From: Daun Johnson on behalf of Planning.Responses
Sent: 05 April 2018 08:41
To: Planning Scanning
Subject: FW: EP/24/18/DOC

From: Fiona Fitzgerald
Sent: 03 April 2018 11:56
To: 'Sarah Hufford'; Anita Gardner; Planning.Responses
Subject: EP/24/18/DOC

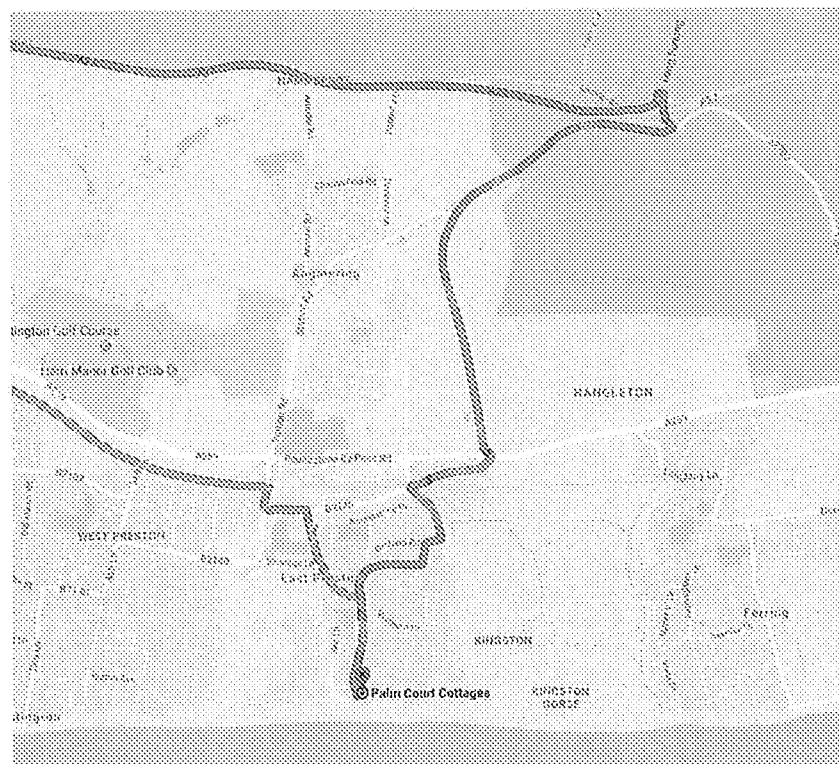
Technically, the information that has been submitted is fine and Environmental Health would be happy to discharge this condition. However, the wording of the condition was put on the planning permission by the Planning Inspector and is slightly different to the wording that we would normally ask for. Therefore I have asked Sarah to submit the following information as a gesture of goodwill:

- Measures to minimise noise (including vibration), including proposed method of piling, careful selection of plant/machinery, any noise mitigation measures
- Measures to control any sources of floodlighting, light sources including intensity of illumination to be used
- Measures to control emissions of dust/dirt during construction (I realise the CMP includes wheel washing already, looking for damping down, covering stockpiles etc.)
